Condition 14

Condition 16

B 24.06.2020 PJR: Baffles added close to site entrance. Voids subbase formation levels added. MK
A 01.06.2020 MJP: Invert levels and gradients to diffuser tanks. MK
REV DATE INT DESCRIPTION CHK

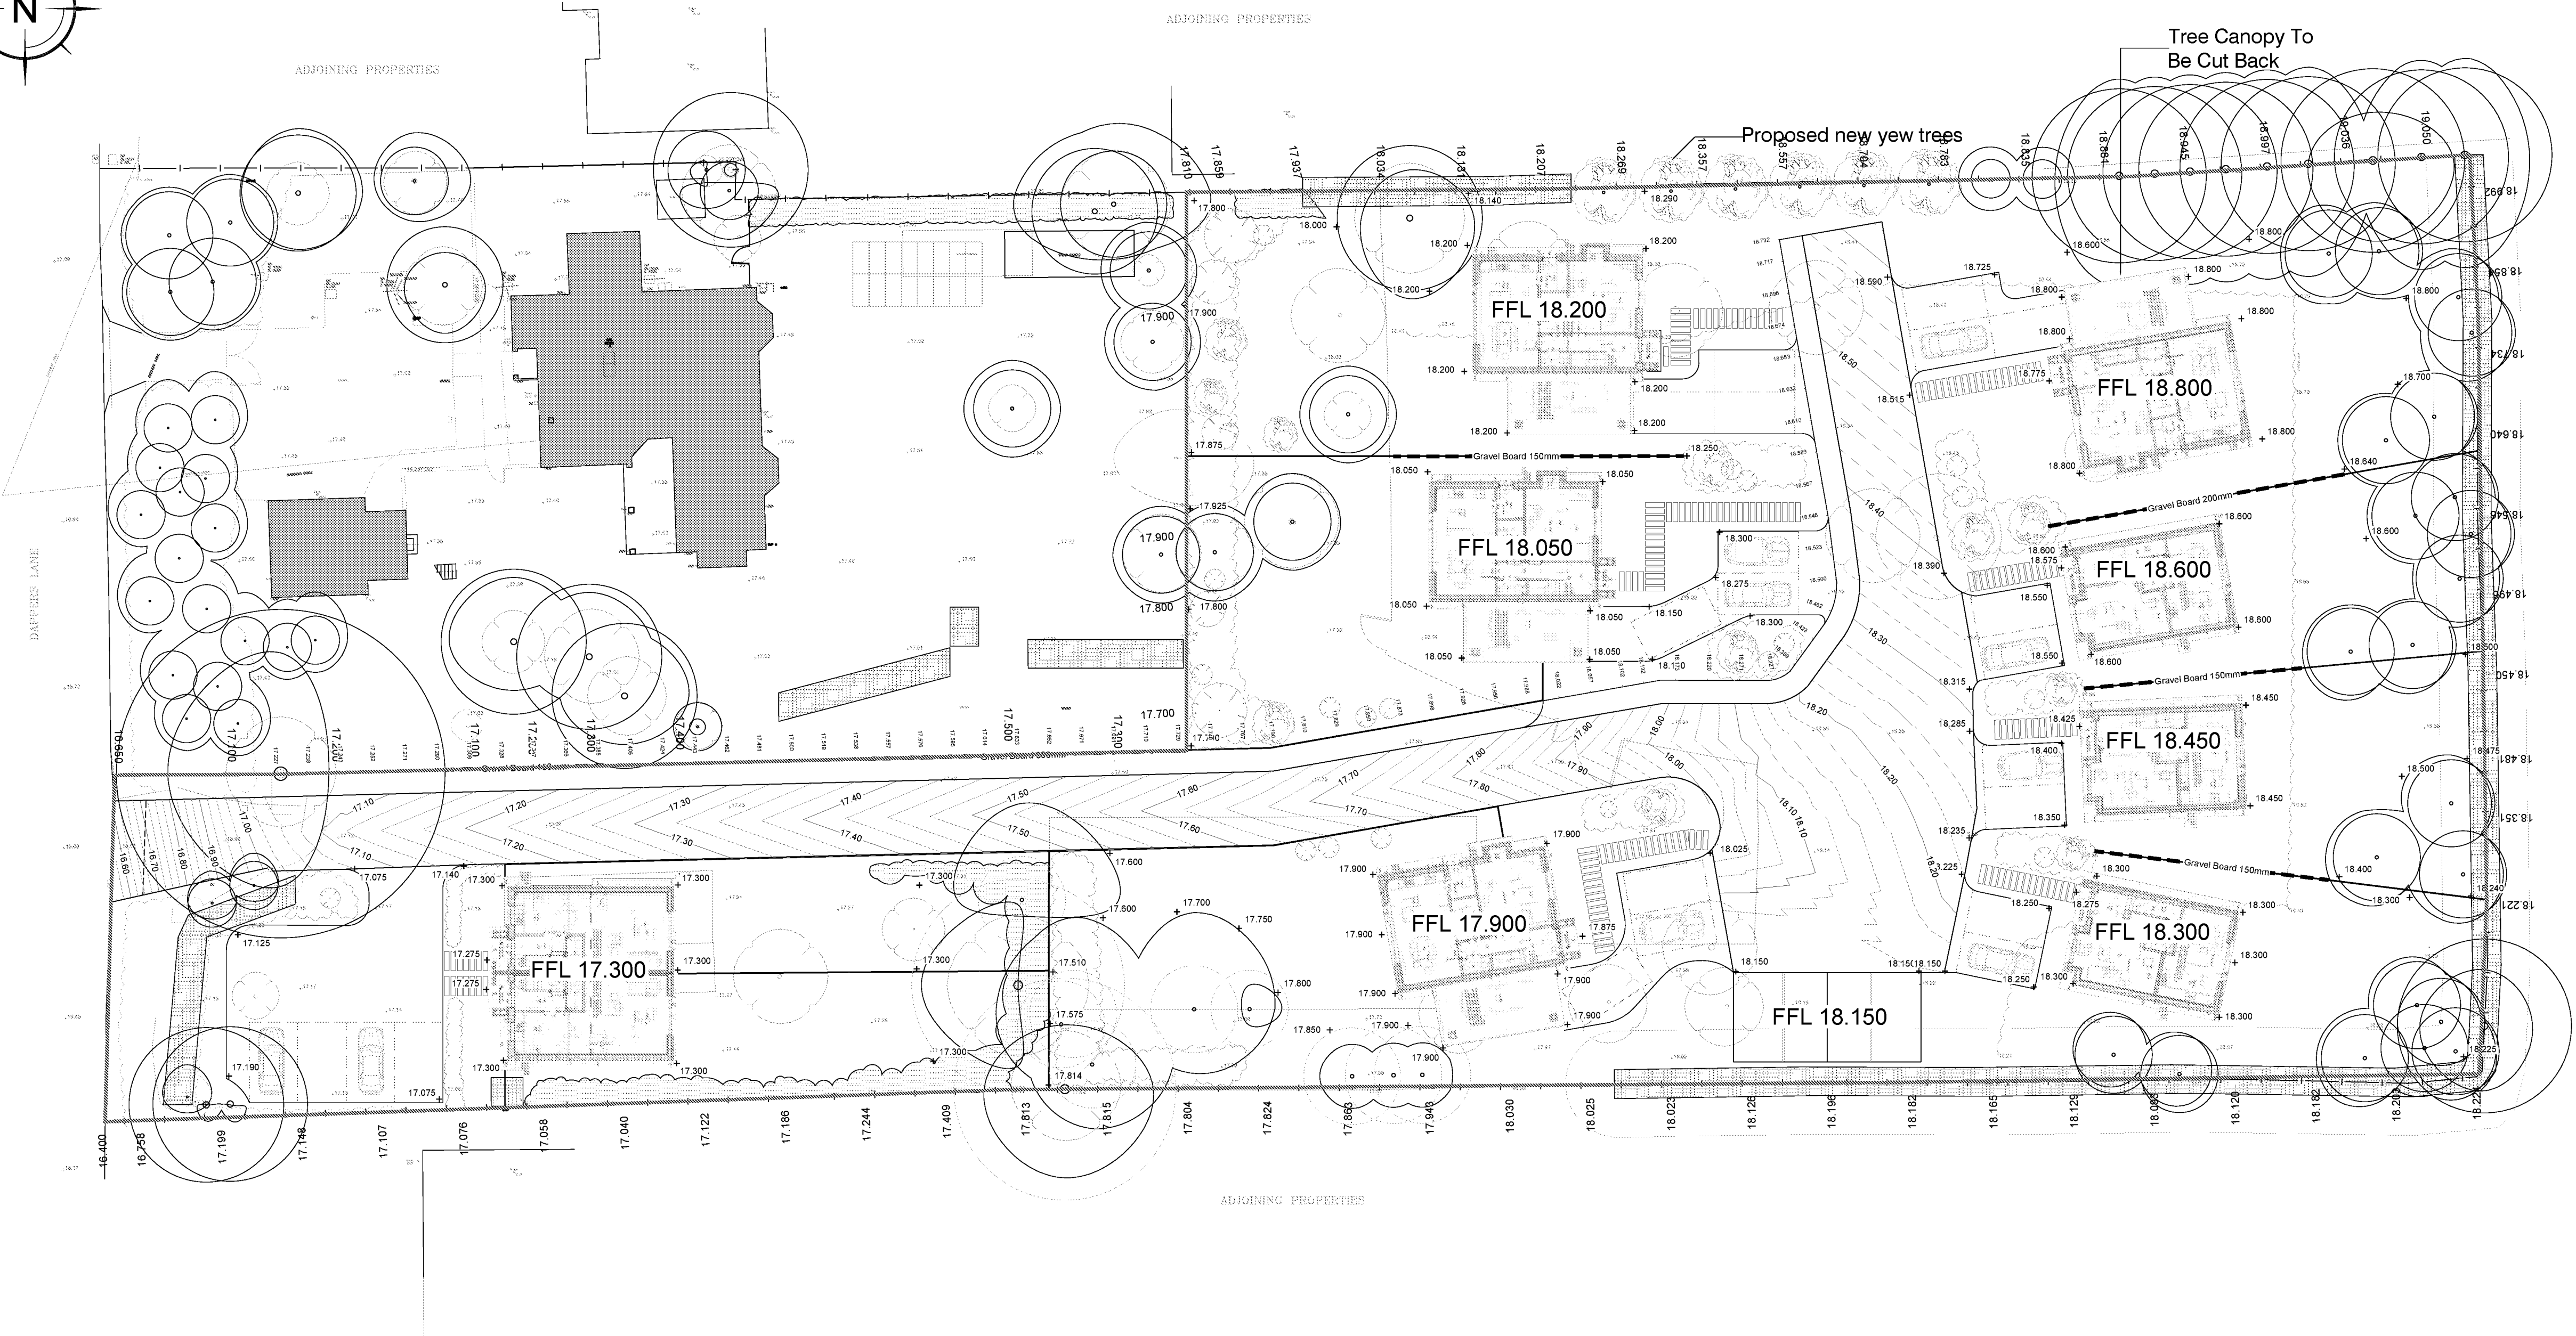
- 1) We have added this baffle between catchments A and C which is now shown on the revised Drawing 201 attached.
- 2) The subbase formation level is flat meaning there is no gradient at the base of the highway construction so each catchment acts as an infiltration blanket. The subbase thickness will therefore vary and will be greater than the minimum thickness required for surface water storage in all cases. We have shown these formation levels on Drawings 103 and 201 attached. Drawing 501 has also been updated including a note stating that the subbase thickness varies.
- 3) This detail has been added to the construction detail on Drawing 501.
